Action ID: SAW-2007-1871-345 County: Henderson

GENERAL PERMIT (REGIONAL AND NATIONWIDE) VERIFICATION

Size and location of property (water body, road name/number, town, etc.): Bridge Number 335 crossing Mud Creek on SR 1238, Pearl Lane, near Hendersonville, NC. (TIP B-3856).

SUBJECT: Review of NCDOT's request for Section 404 and 401 Permits and the Categorical Exclusion document to replace Bridge No. 335 on SR 1238 (Pearl Lane) over Mud Creek, Henderson County, North Carolina. TIP No. B-3856.

STATE OF NORTH CAROLINA
 DEPARTMENT OF TRANSPORTATION
 RALEIGH
 TRIPLE 8 FT. X 8 FT.
 CONCRETE BOX CULVERT
 80° SKEW

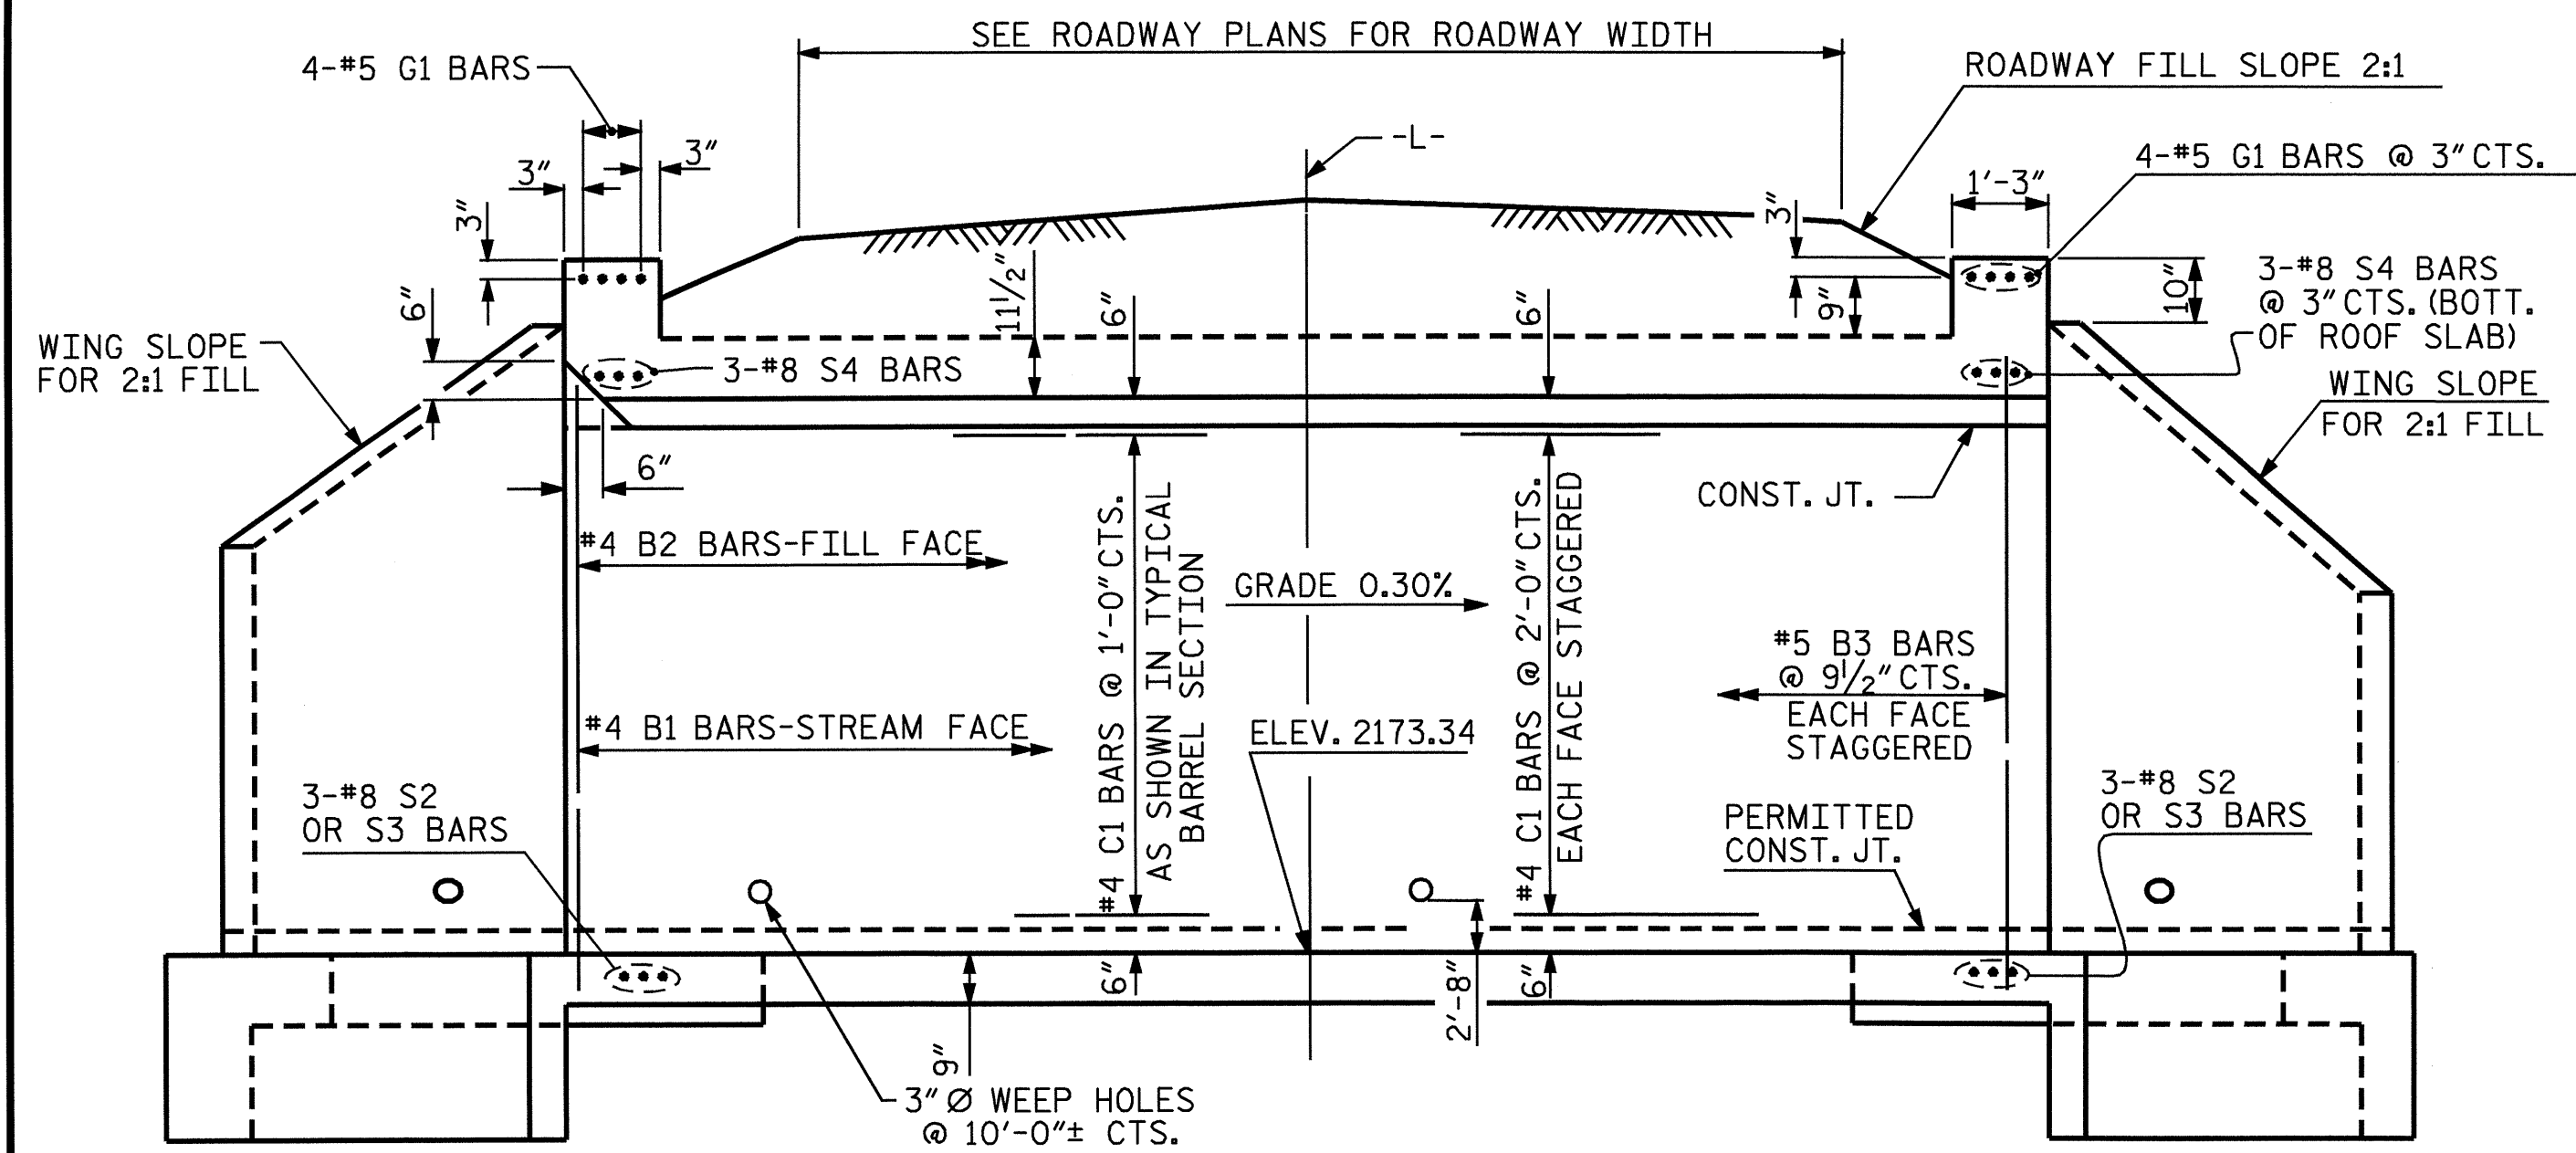
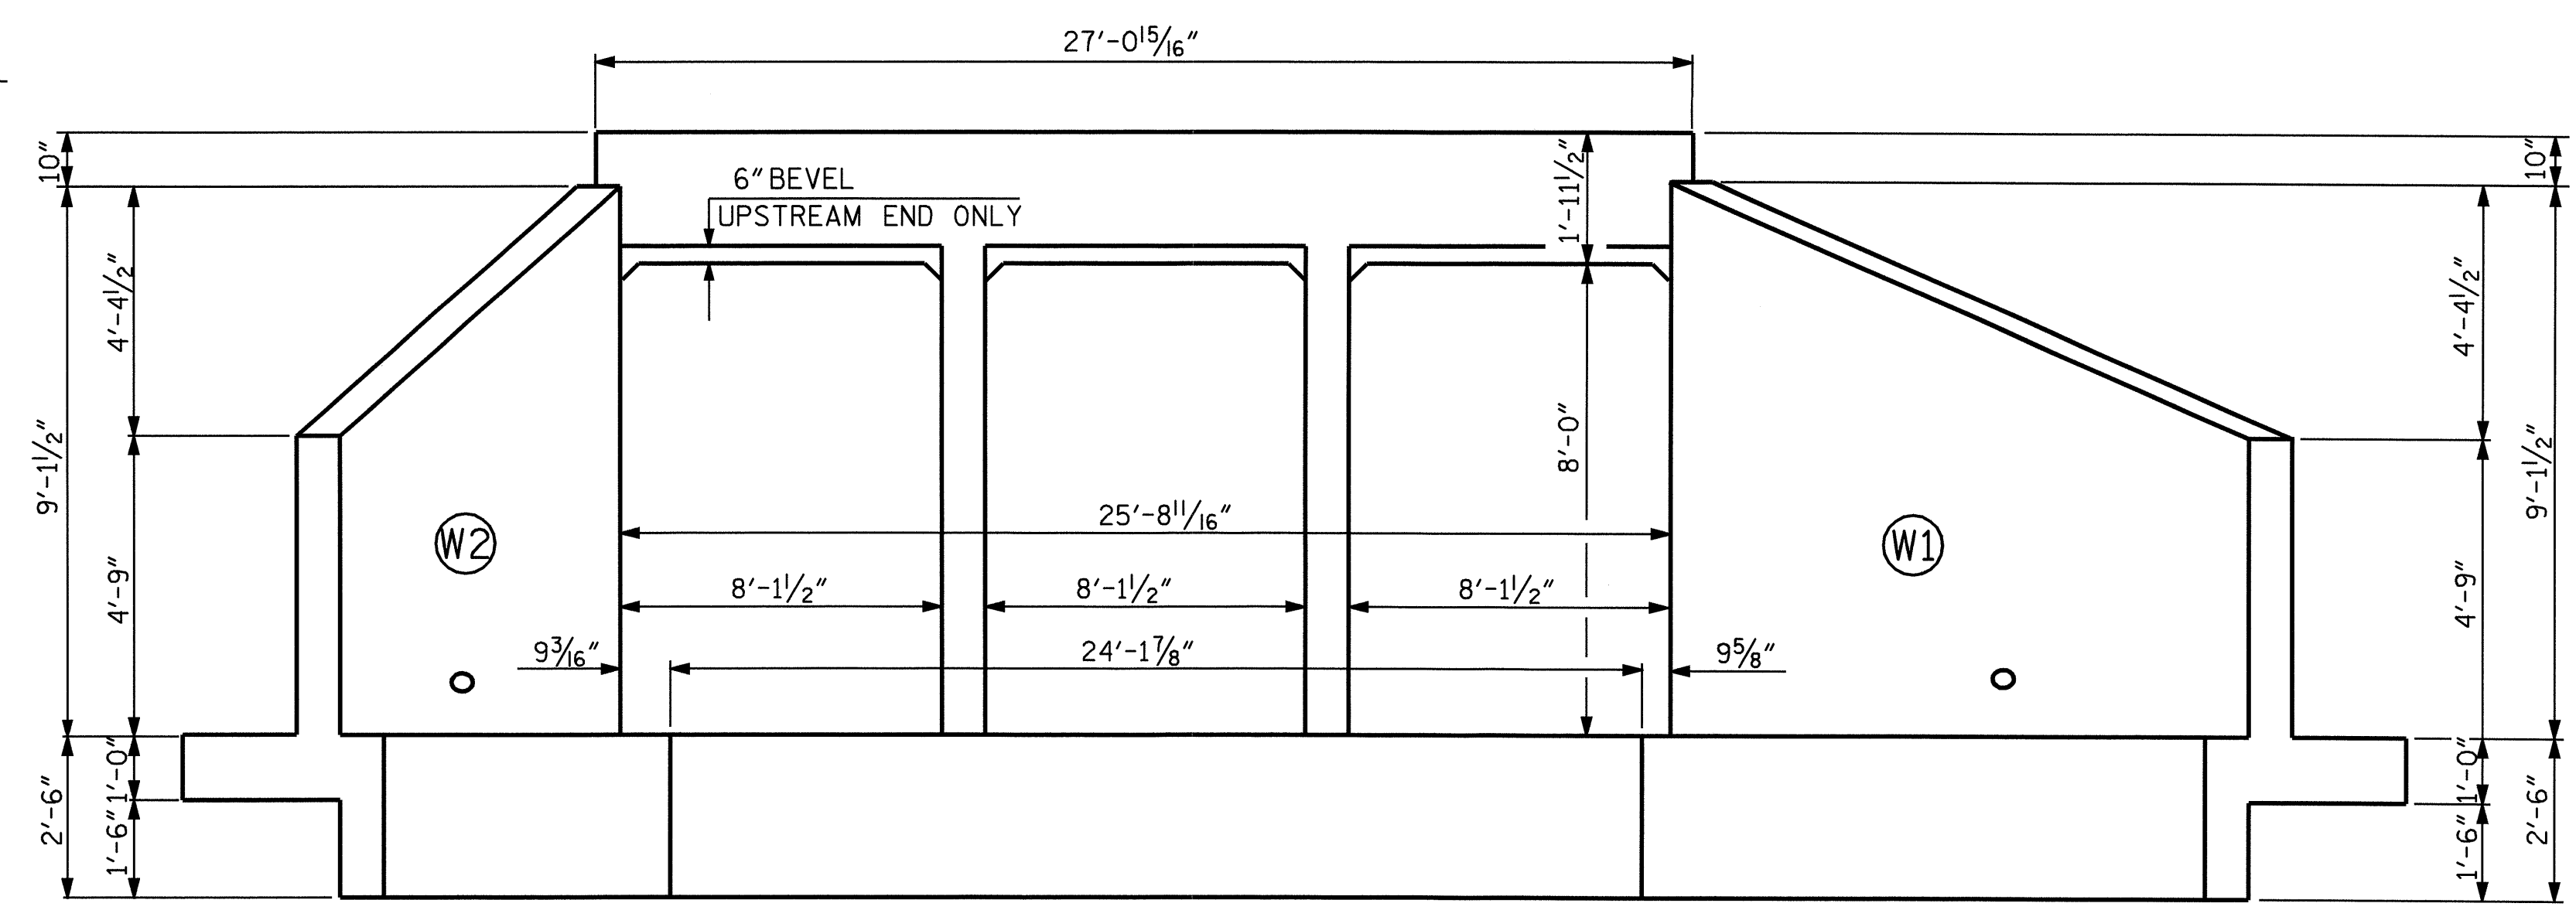
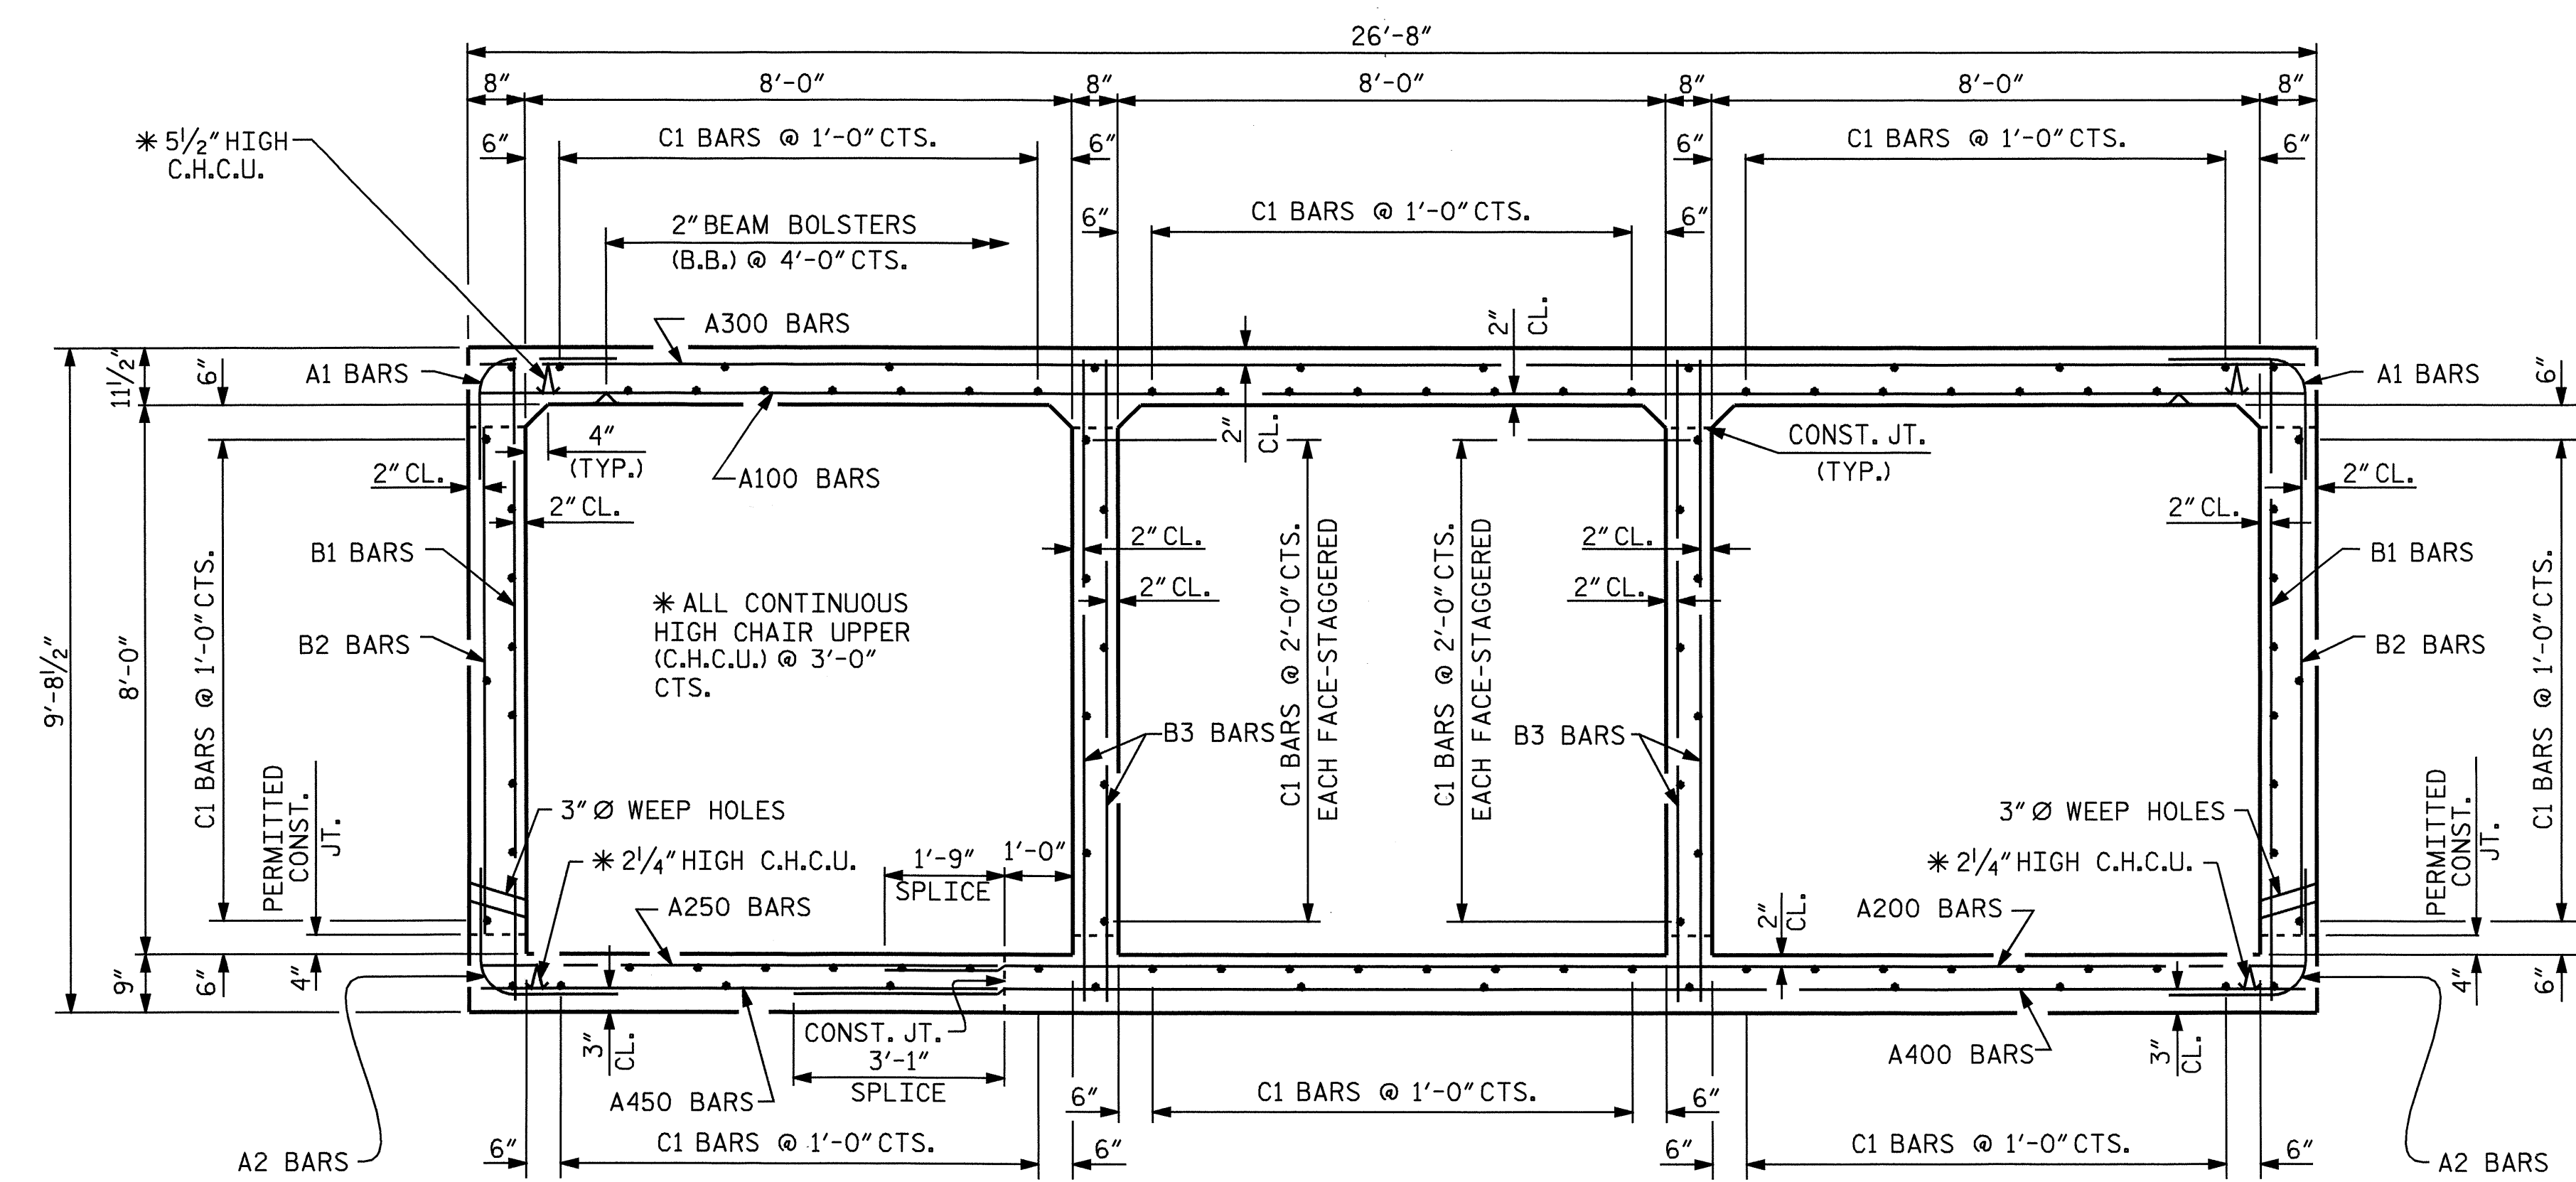
Mud creek is on the 303(d) list of impaired waters most of its length through Henderson County. NCDOT should consult with NCDWQ to determine if the project area is listed or subject to any special requirements. NCWRC recommended a bridge be used instead of a box culvert in our scoping comments dated January 31, 2002. We are very concerned that the culvert design will hinder fish passage and destabilize the stream channel, further deteriorating the quality of the

stream. The average baseflow width of Mud Creek in the project area is approximately 5 feet and the average depth is approximately 7 inches. Placing a 5-foot wide stream in a 9-foot wide culvert barrel will significantly widen the flow and decrease the depth, reducing the crossings ability to pass aquatic life. Stream channel aggradation and degradation may occur upstream and downstream of the culvert as a result. A re-design of the crossing may be warranted. At a minimum, installing alternating baffles in the baseflow barrel may improve the flow pattern and increase the water depth in the culvert, helping to alleviate these concerns.

4. Consider a re-design or installation of alternating baffles in baseflow barrel. If used, culverts that are 48-inch diameter or larger should be placed with the floor of the barrel approximately 12 inches below the stream bottom to allow natural stream bottom materials to become established in the culvert following installation and to provide aquatic life passage during periods of low flow. These measurements must be based on natural thalweg depths.

5. Culverts should be designed so that one barrel, of adequate size, will carry the base flow, and the others will carry stormwater. Barrels other than the base flow barrel should be placed on or near bankfull or floodplain bench elevation (similar to Lyonsfield design). This may be accomplished by utilizing sills on the upstream end to restrict or divert flow to the base flow barrel.
